Mr Ed Mounsey
Head of Development
CWP Renewables Pty Ltd
PO Box 1709
Newcastle NSW 2300
Via email: Ed.Mounsey@cwprenewables.com

07 July 2021

**Boco Rock Wind Farm Modification 1 (MP09_0103-Mod-1)
Biodiversity Assessment**

Figure 3 Proposed Modification to WTG dimensions

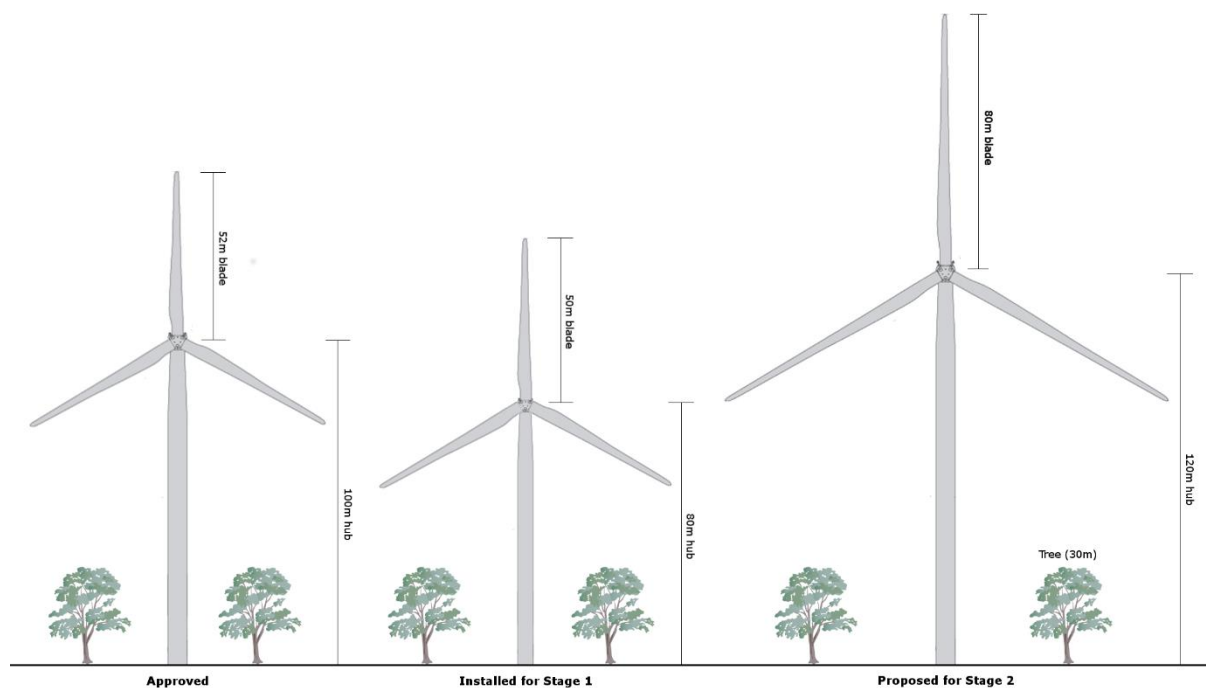
Based on the information available, the proposed modification would appear to increase impacts on some of the listed biodiversity values, including the 'flight path integrity' (due to additional turbine height) and potentially 'vegetation abundance' (due to increased size of turbine base).
